Rampion 2 Offshore Windfarm – EN010117
Interested Party Reference – 20045298

Response from the South Downs National Park Authority to the Examining Authority's Action Points from Issue Specific Hearing 2 (ISH2)

Appendix D – SDNPA comments on other Deadline 3 Submissions

Figure 7.2.6m Combined Vegetation retention Plan'

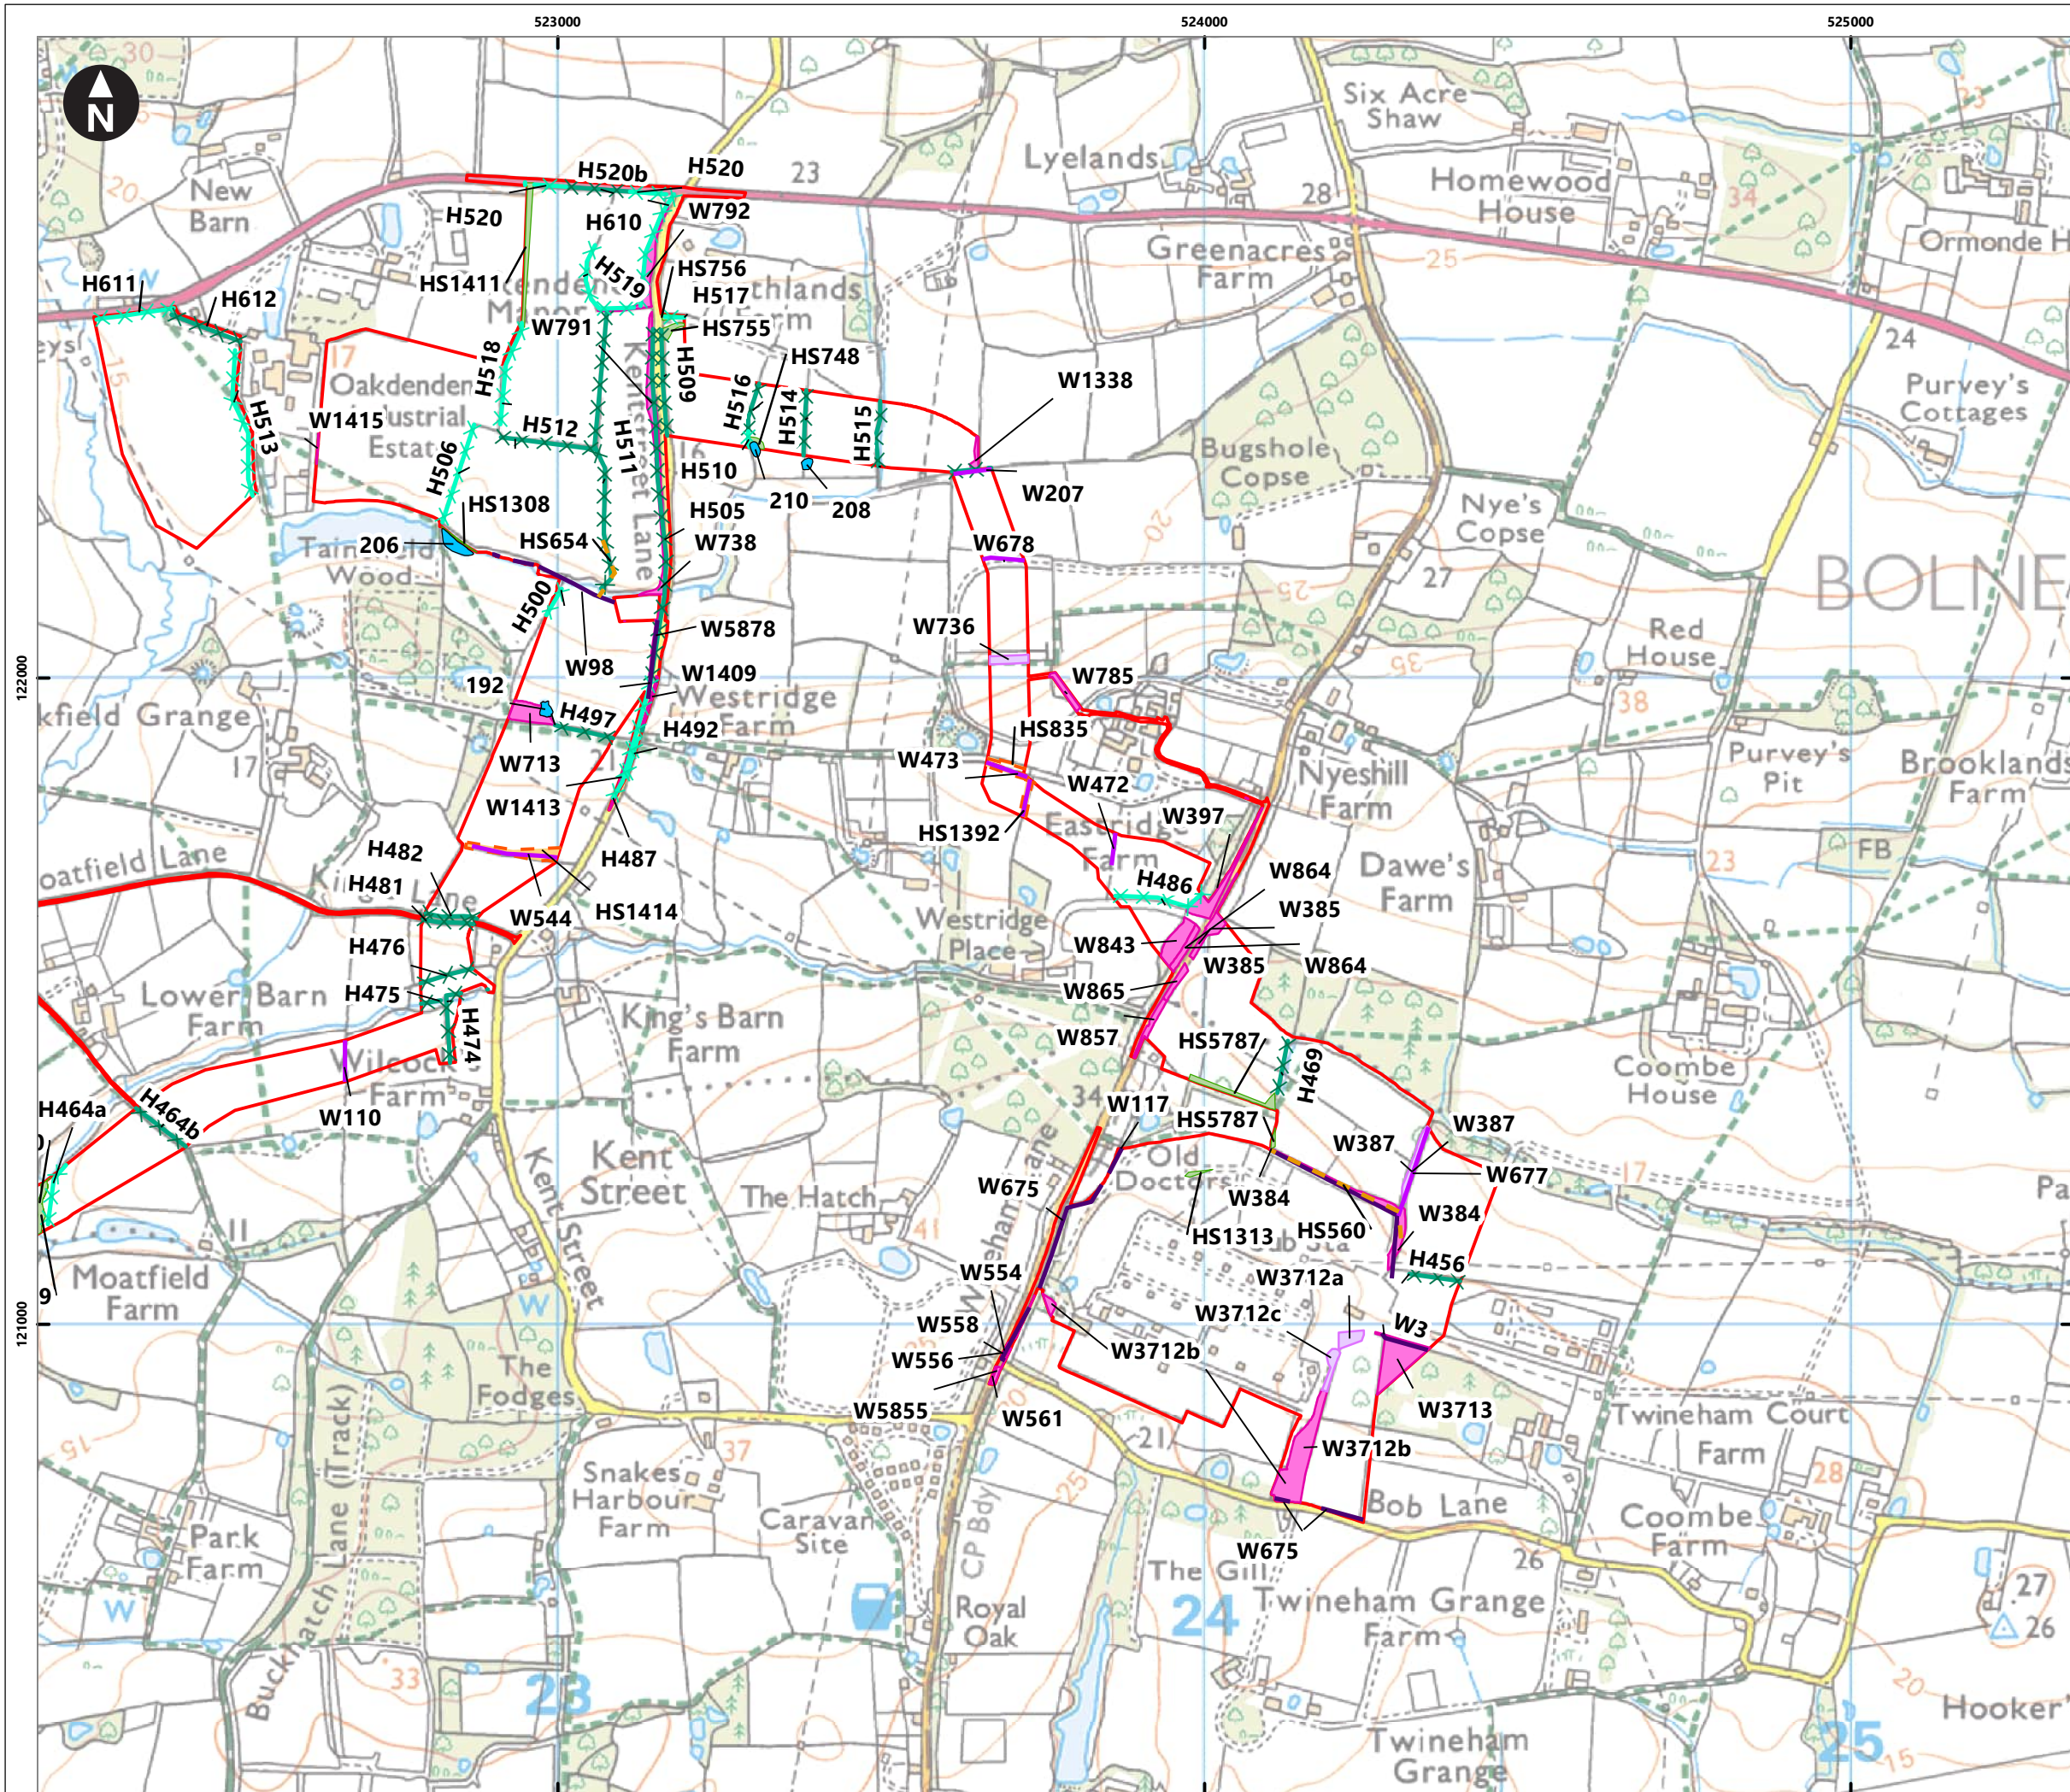
- 2.3 Whilst the inclusion of consolidated vegetation retention plans at Appendix B is welcomed, there remain a number of discrepancies contained within the plans. The SDNPA are aware that WSCC are providing comprehensive details of these anomalies and how they should be resolved. The SDNPA support these recommendations, in particular, provision of a more accurate and realistic assessment of what is to be removed, temporarily or permanently lost.
